Meadow Lake Airport Association

Date: December 20, 2024

Subj: **Request for Variance of Use, Revised**

Ref: (a) VA 247: 8242/8244 Cessna Dr, Lot 3 Blk 1 Meadow Lake Airport Fil No 2, 43040-02-047

8242-8244 CESSNA DRIVE VARIANCE OF USE SITE PLAN

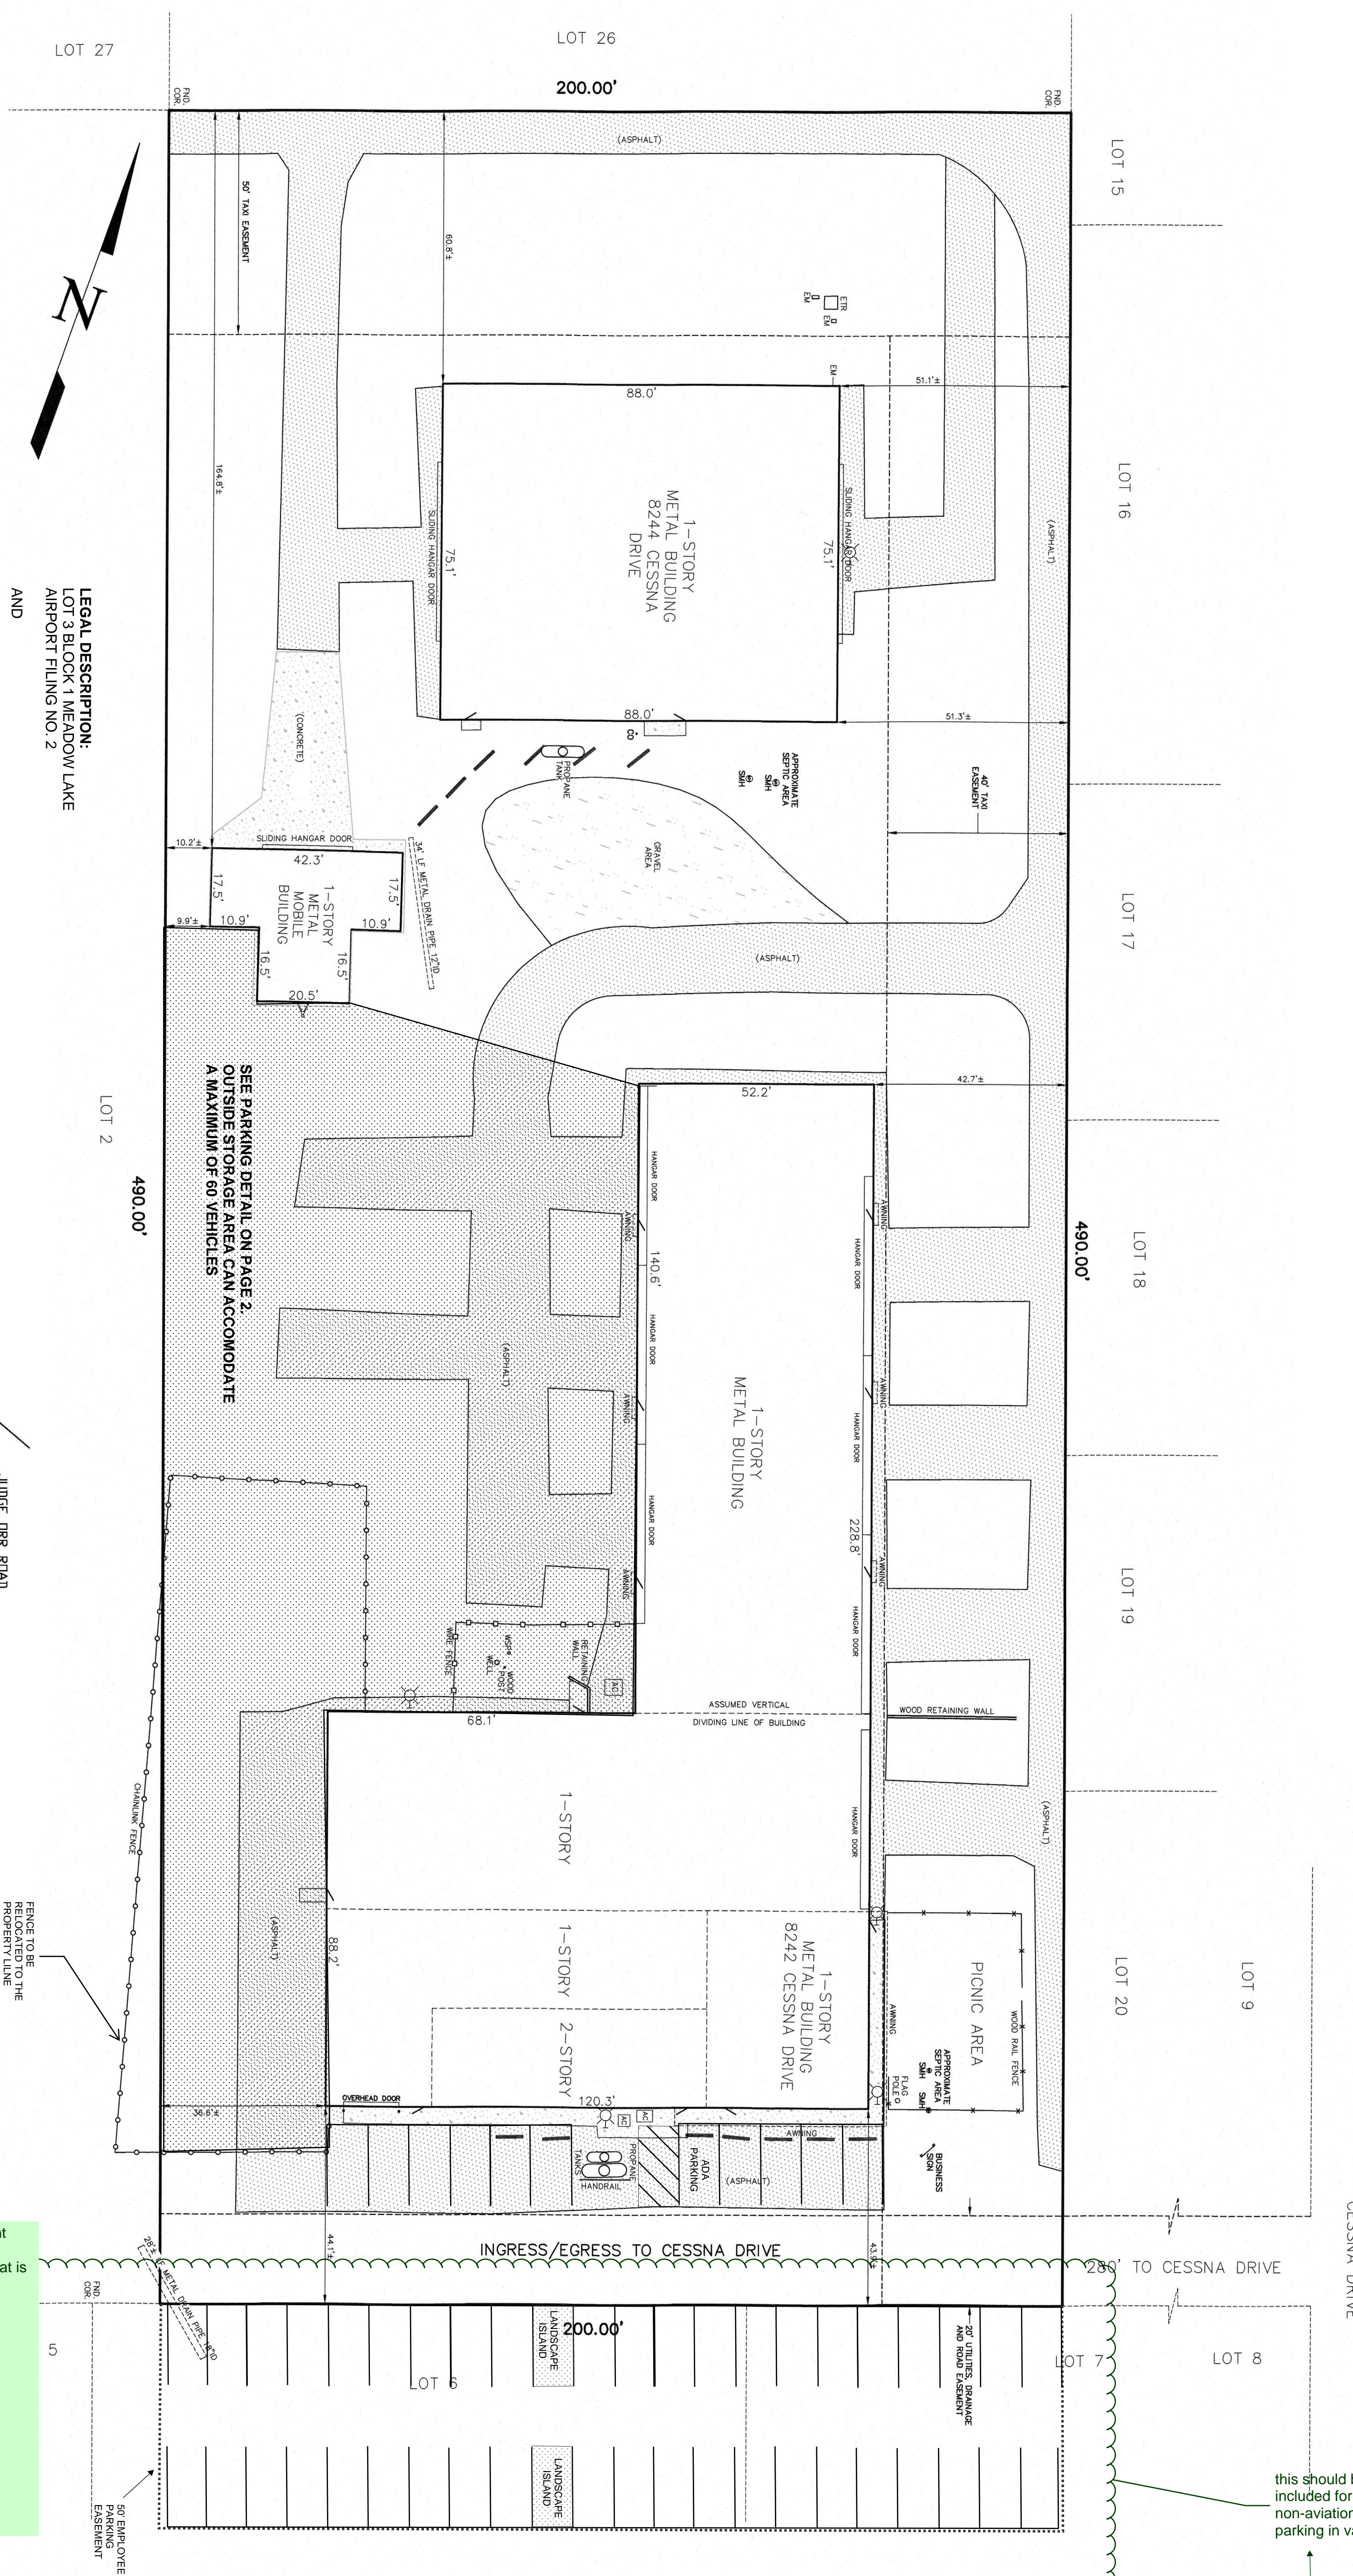
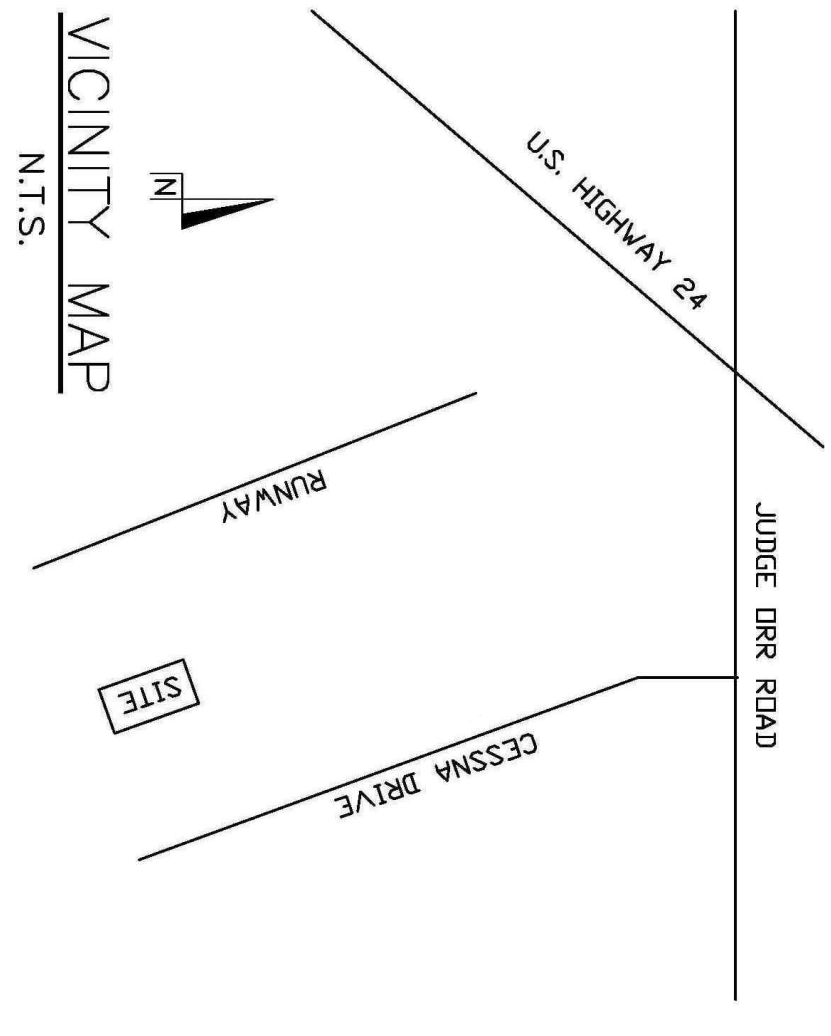
The use intended is much too large for the space available. Applicant has requested additional space from neighboring lots, and has only obtained temporary use of the lot to the south for his employee parking. Exhibit A depicts a 50' Parking Easement on the neighboring lots to the south of the subject property. This 200 foot parcel covers the north portion of Lot 7, Block 1, Meadow Lake Filing No.2. Lots 6 and 7 were merged to create the High Altitude Aero Condominiums. Ryan

In addition, the revised site plan for the primary lot indicates nine "un-used" parking spaces along the north side of the "Fleet Building". Meadow Lake Airport is designed to Group 1 Airport Design Group (ADG) standards. Taxiways for Group 1 have an Object Free Area (OFA) of 89 feet (44.5' either side of the taxiway centerline). Meadow Lake was designed with easements for the east-west access taxiways to be 100 feet wide, centered on the property boundaries (50 feet inside each property). Therefore, the spaces indicated on the site plan cannot be used for parking since they would violate the FAA Object Free Area (OFA) requirements for a Group 1 taxiway.
